Joe Russell-Wells
Greenspace
37914

Peter Cleveland
Planning Services

LAND OFF ROUNDSTONE LANE, ANGMERING – A/82/12

scheme: Roundstone Lane
Angiering
client: Barratt David Wilson
drawing: Soft Landscape Proposals
date: July 2012
scale: 1:200@A1
drawing no: BSH 17576 19
drawn: DKM checked: AW

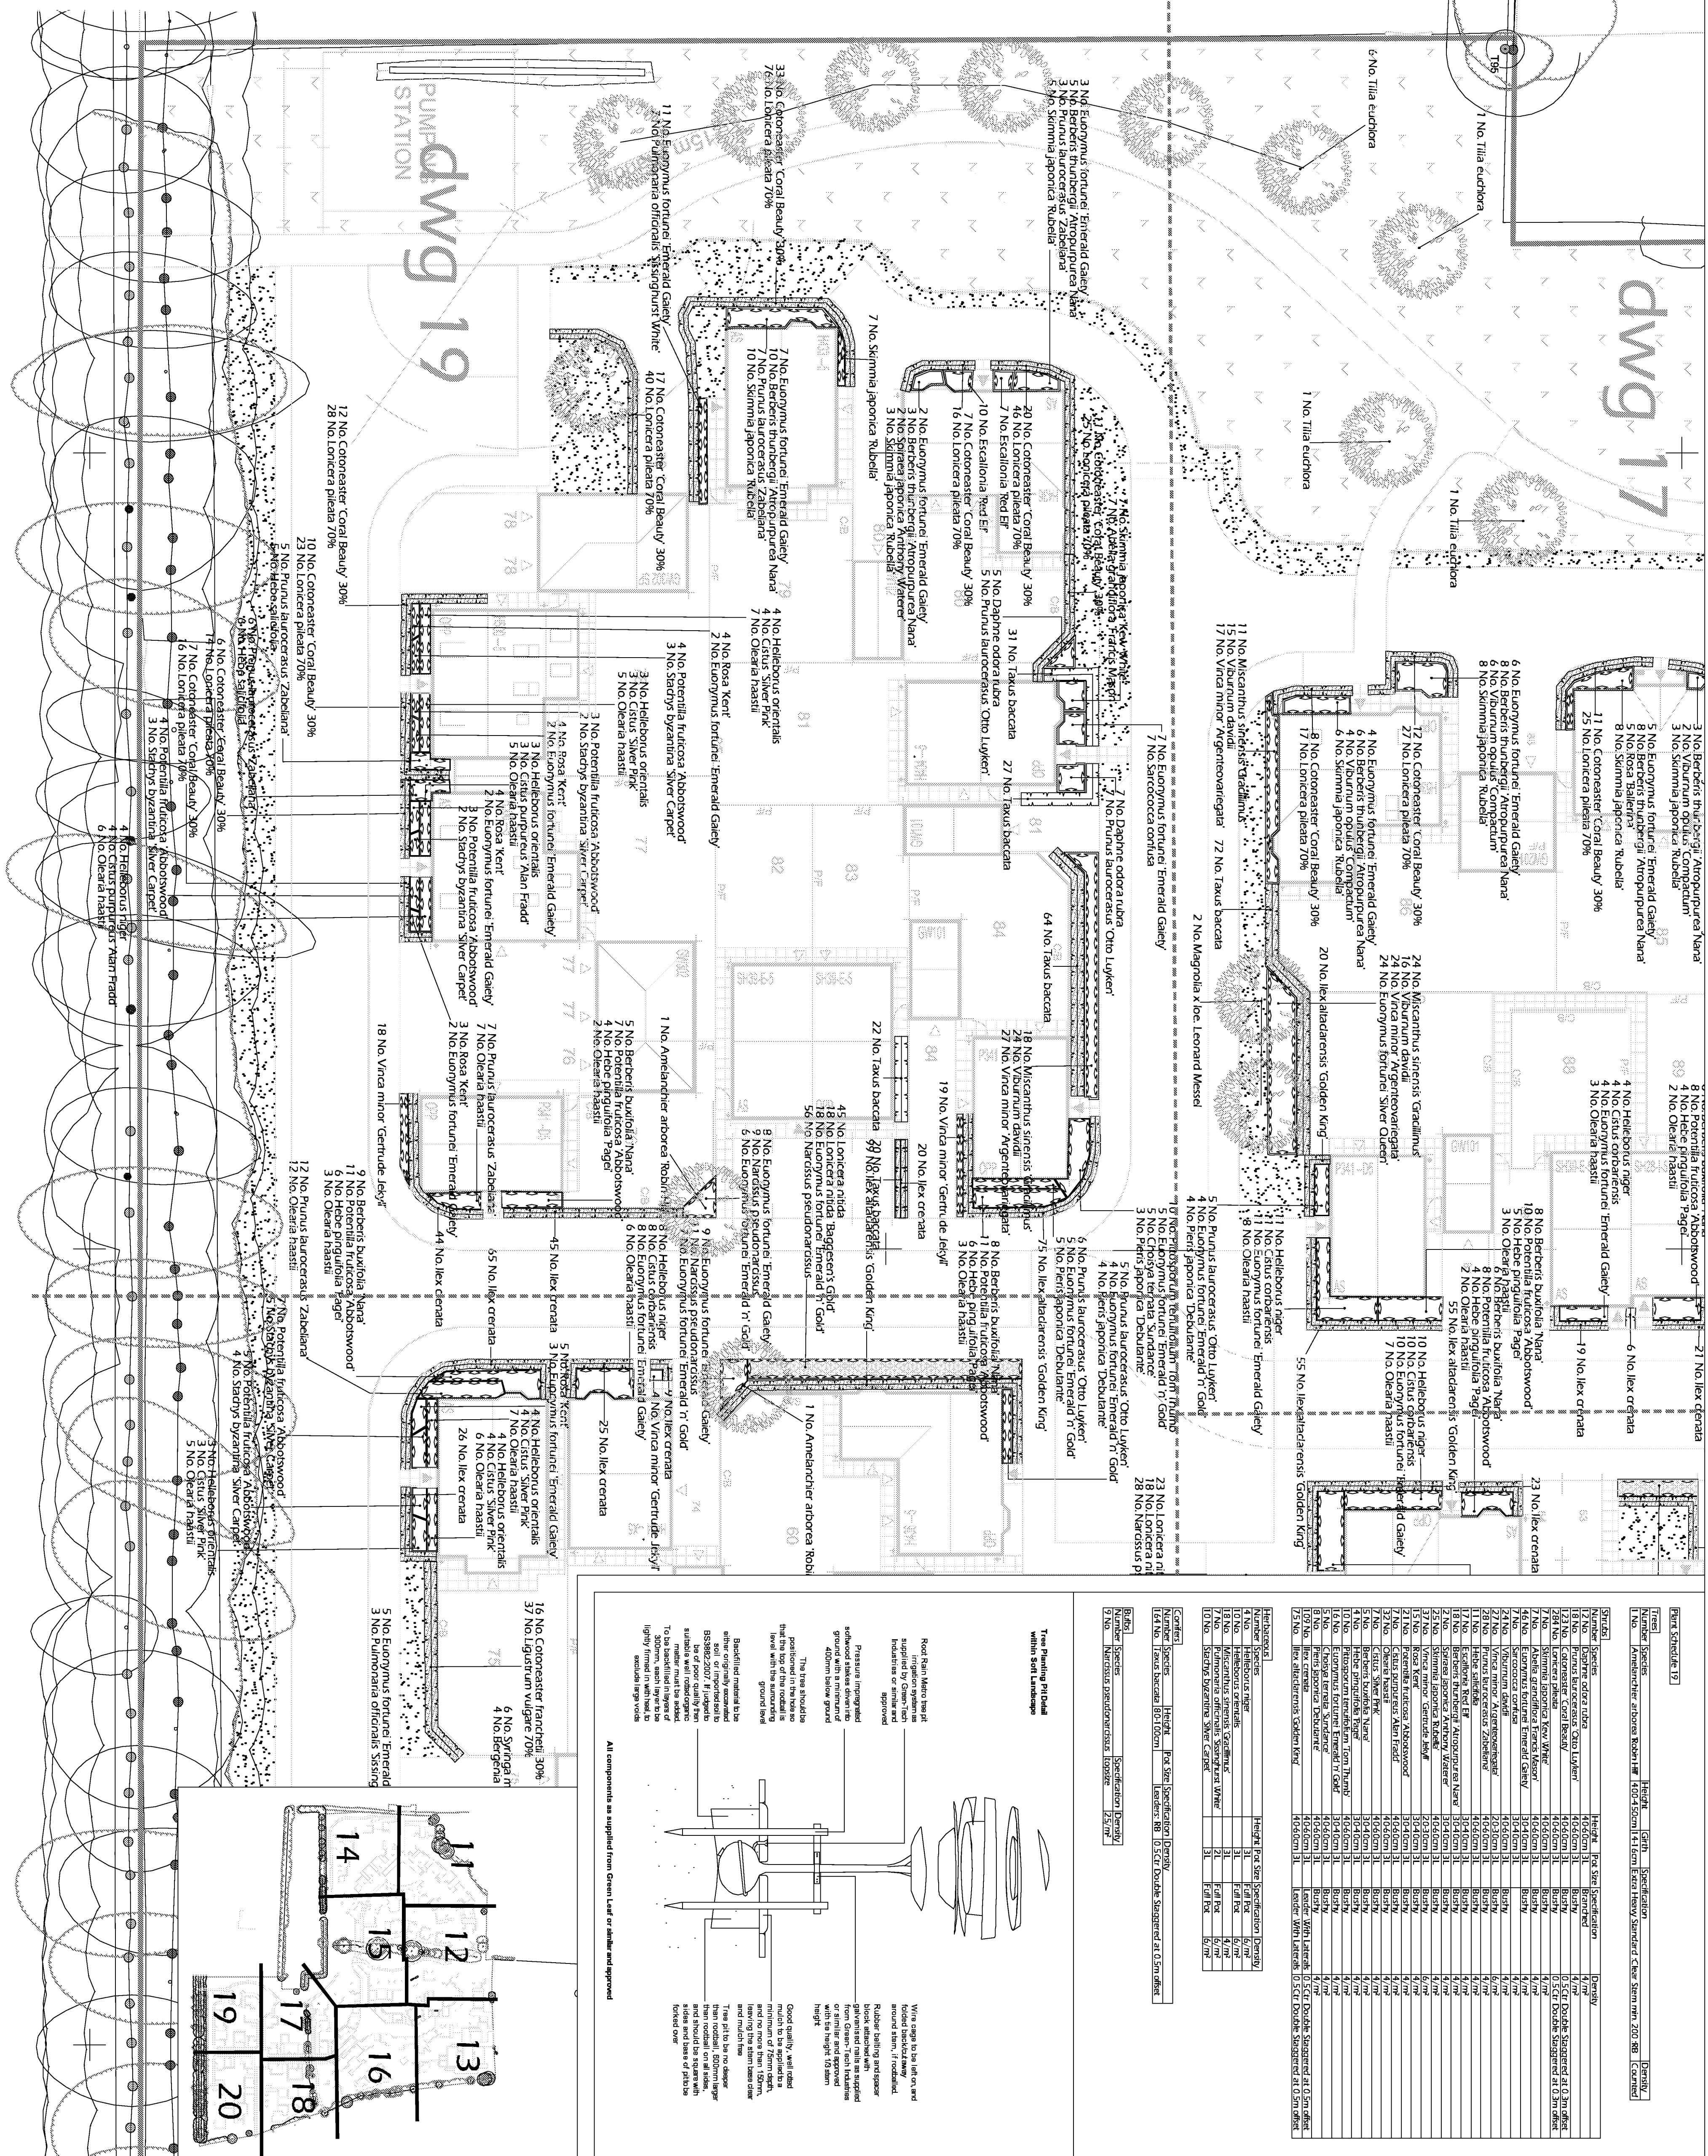
In accordance with the Council's current SPG sufficient POS is being provided. The layout has been determined by following the existing hedge and tree line features across the site to maximise the retention of existing features on the site, however this has led to very linear open spaces and does not allow for larger spaces for ball games. This is a popular use of such spaces and the cause of significant complaint by some residents where space does not allow. The 'Community Garden' is not fully defined and may also not allow for ball games.

An area of POS must be accommodated on site to allow for use for ball games etc. Additionally a larger area of POS will accommodate a play area allowing for adequate buffer limiting nuisance for adjacent properties.

Vehicular access to units proposed on the POS frontage must properly accommodate. Experience has shown with this type of development where access is not provided any opportunity is taken to make access, or that access is

The play provision of one LEAP is adequate. The location for the LEAP is at very close proximity to housing and at their frontage which is likely to cause too greater a degree of nuisance. As referred to above the play area must be located in a larger POS area to allow for successful integration into the development.

Information on the drainage of the site has not been provided in relation to POS area other than an 'infiltration swale' within three areas of POS. If a SUDS is required they are often included with POS areas by their nature. The full implications of any scheme must be provided to ensure this sits well with any POS provision. This information must be provided as part of the outline application.

The proposed retention of all boundary vegetation is welcome and certainly necessary to reduce the impact of development. A further point of mitigation is that 'development should also be kept back from the sight boundaries to allow for boundary planting and screening elements and minimise impact of built form'. This additional boundary planting must be clearly indicated, quantified and identified on plans to ensure this is sufficiently provided and therefore adequate as part of the outline application and not left until reserve matters applications.

In addition the eastern boundary appears to be beyond the red edge of the development and therefore not within its control. Who would ensure this boundary is satisfactorily maintained as a screen into the future? It is noted that parts of the screening vegetation is comprised of Elm which are likely to suffer from Dutch Elm
